August 1, 2007

**Re: Status of Improvement Permit Application #07-5-18024**  
**Lt 5 Elvis Faircloth**

SITE PLAN APPROVAL

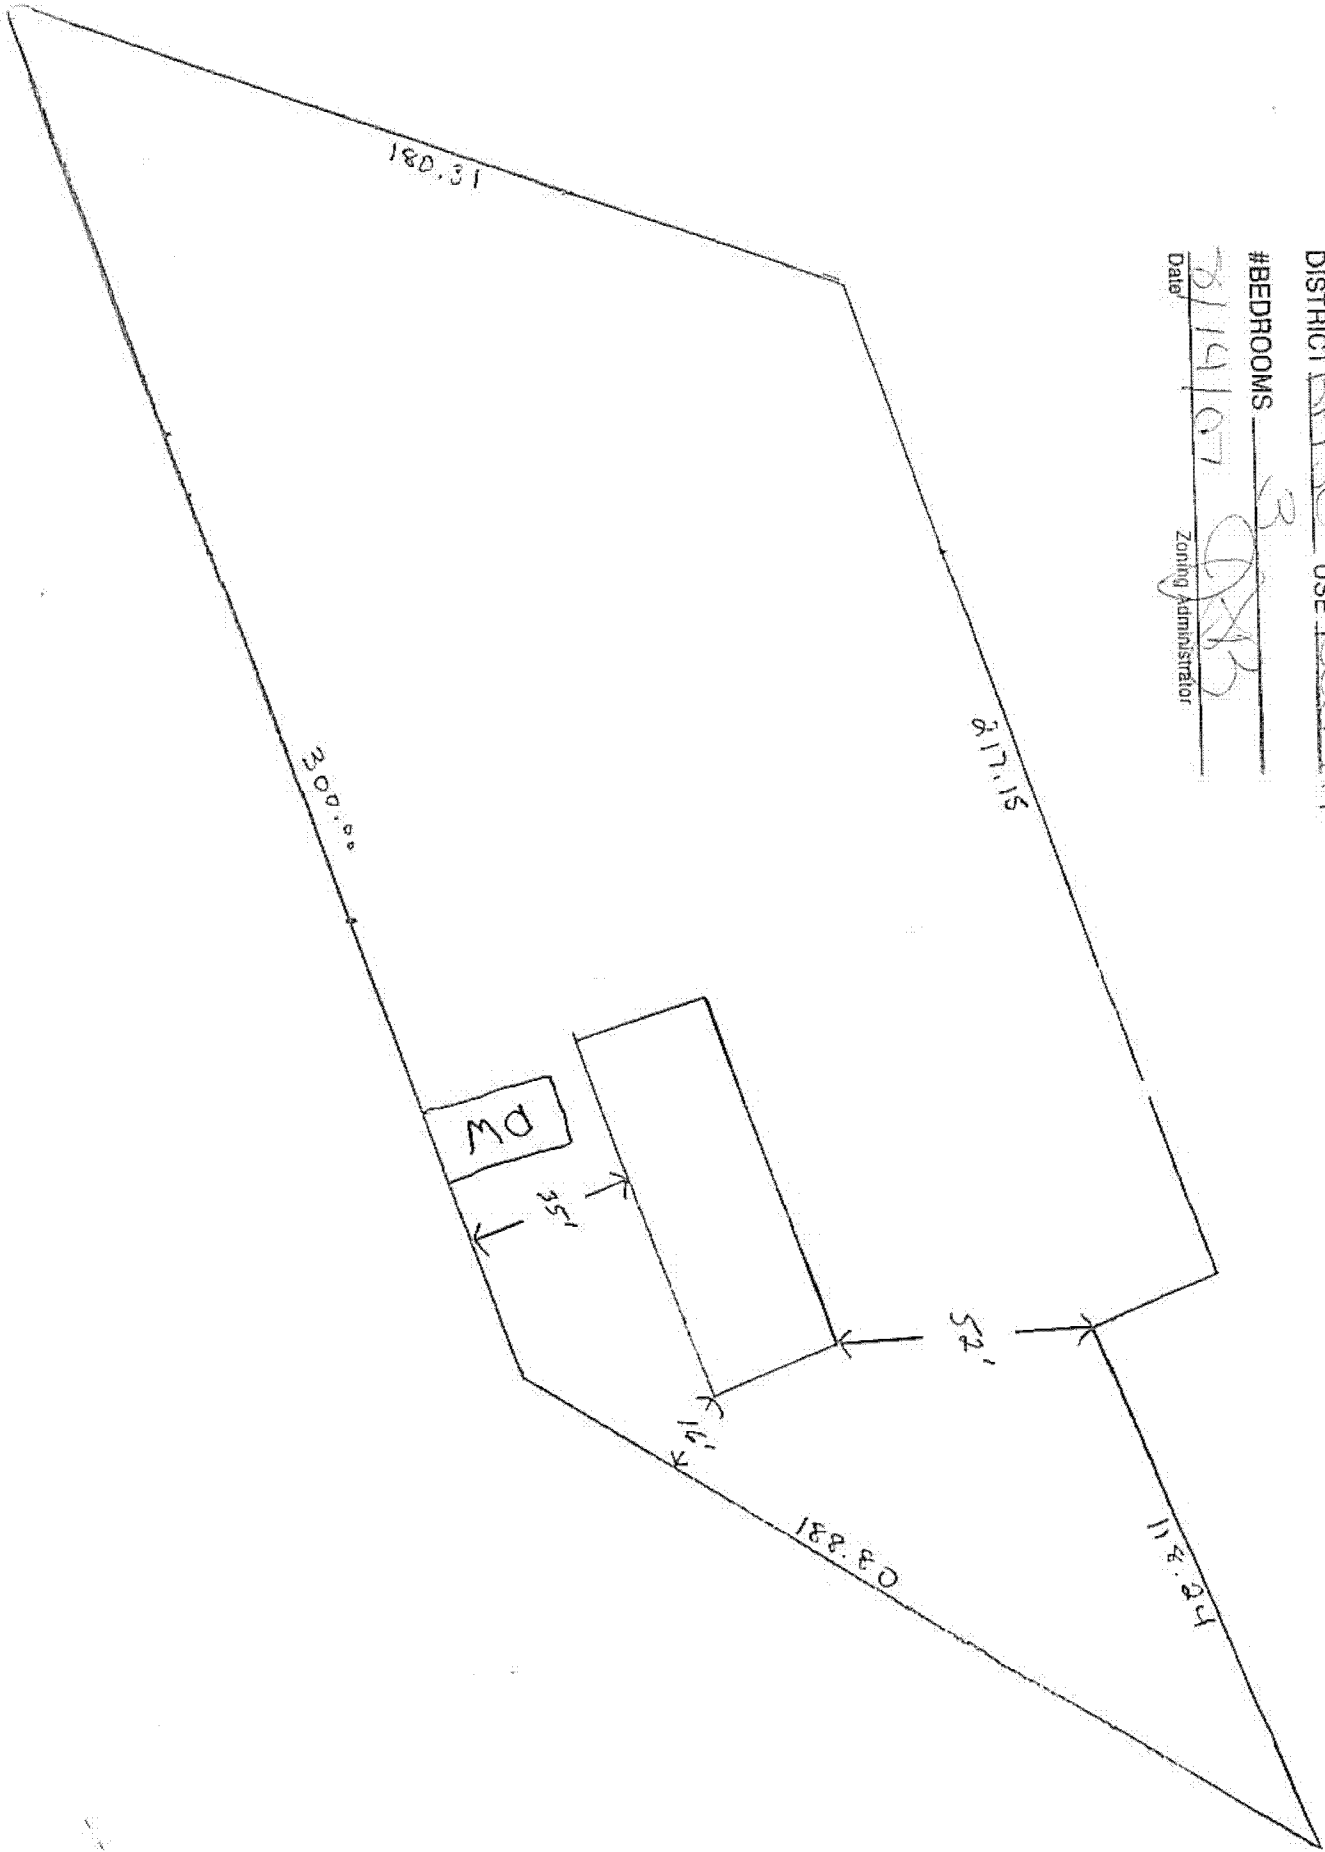
- 1. Property lines/corners not marked or labeled
- 2. House corners not marked or labeled
- 3. Directions not clear to property
- 4. Property needs brush or vegetation removed
- 5. Backhoe pits required
- 6. **Other – Move house as shown and reduce to 3 bedrooms and submit new plot plan to Central Permitting.**
